Recommendation Report for Prior Notification of Work to Tree(s) in a Conservation Area

REF NO: Y/1/18/TC

LOCATION: Berri Court
Main Road
Yapton
West Sussex

PROPOSAL: Fell & Replace 1No. Corsican Pine, 2No. Eucalyptus, 1No. Cherry, 1No. Horse Chestnut & 1No. Monterey Cypress. Fell 1No. Tree of Heaven, 2No. Eucalyptus, 9No. Leylandii Cypress, 2No. Cypress, 1No. Rodedendron, 1No. Larch & 1No. Pittosporum & Various works to various trees within Church Road, Yapton Conservation Area.

## BERRICOURT TREE PLAN

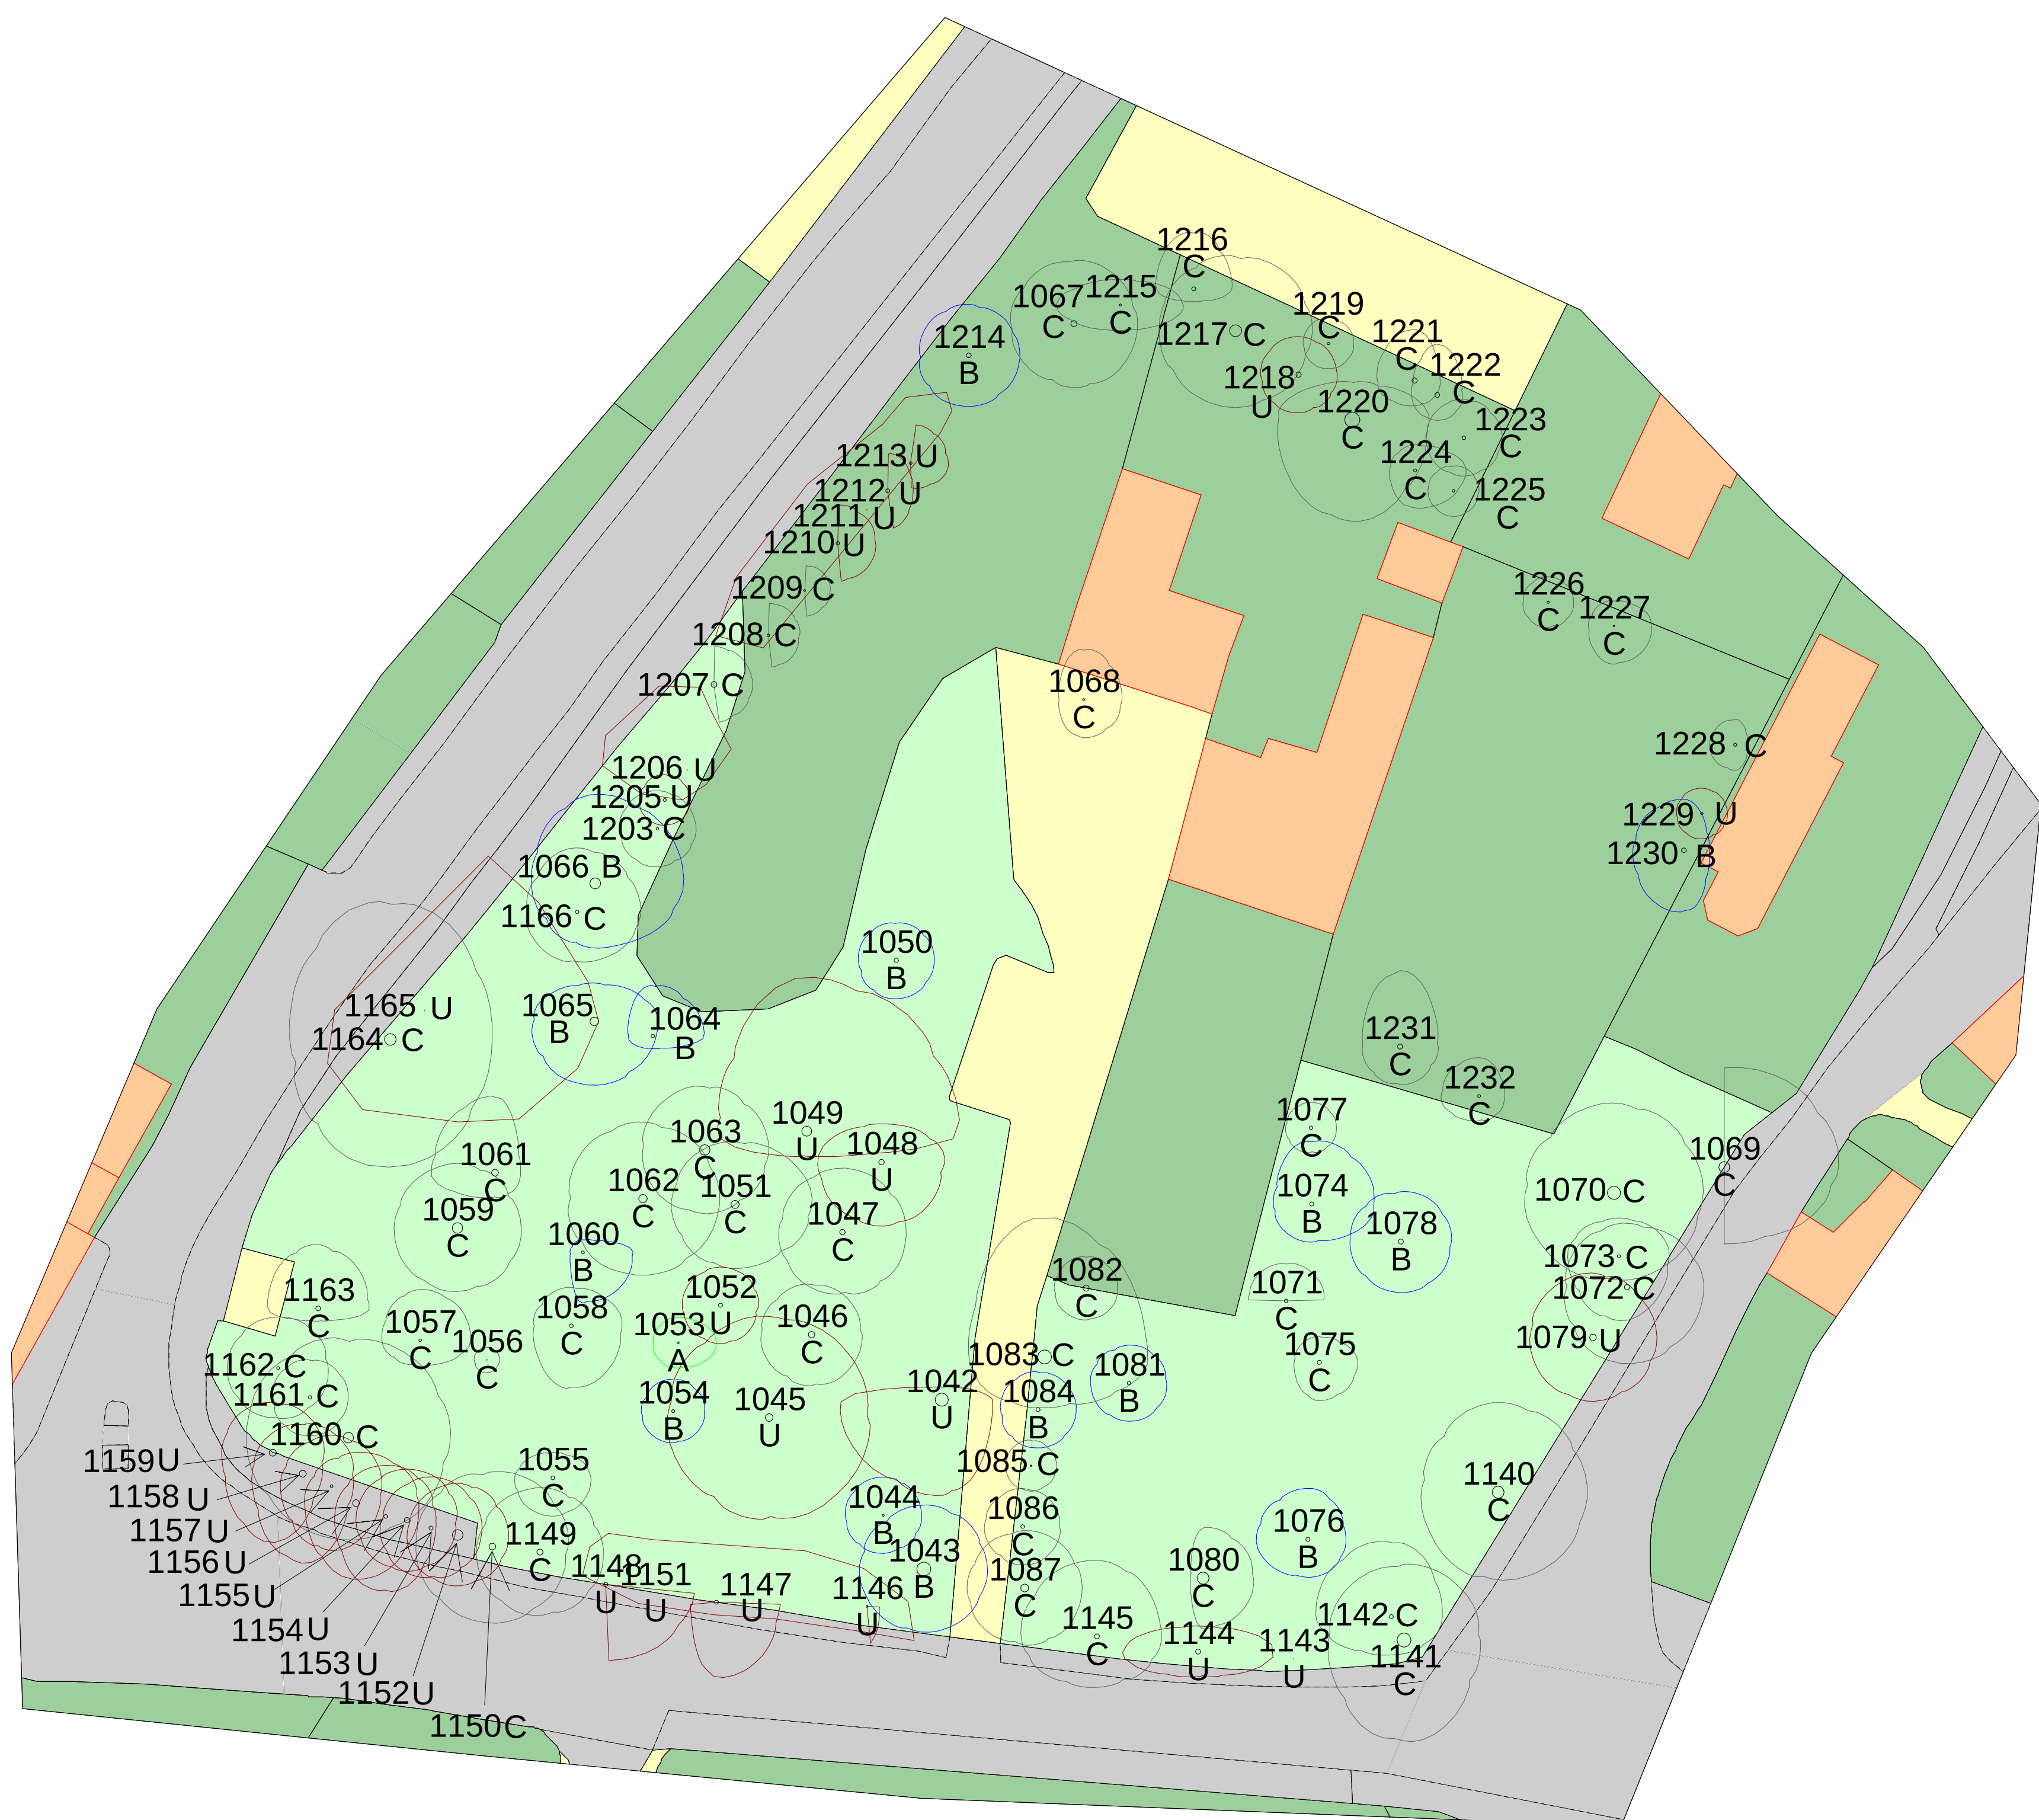
The mature Eucalyptus tree (T88) which dominates the rear aspect of the property and is visible from the surrounding area. It is of unusually fine form and has apparent good health. The applicant has determined it to be of low quality (a view with which I disagree) and proposed its removal. It scores 17 using TEMPO and is worthy of an Order.

I recommend the making of an individual Tree Preservation Order in respect of one Eucalyptus. Identified as Tree No 88/Tag No 1217 on the aforementioned tree survey/, I attach the appropriate TEMPO form and site plan to assist you in making this order.

The applicant was contacted regarding the removal of the Eucalyptus Tree No88 Tag No 1217 from the application whilst the TPO Order was created under instruction from the Arboriculturalist. This was agreed and subsequently the tree has been removed from the description of proposed works.
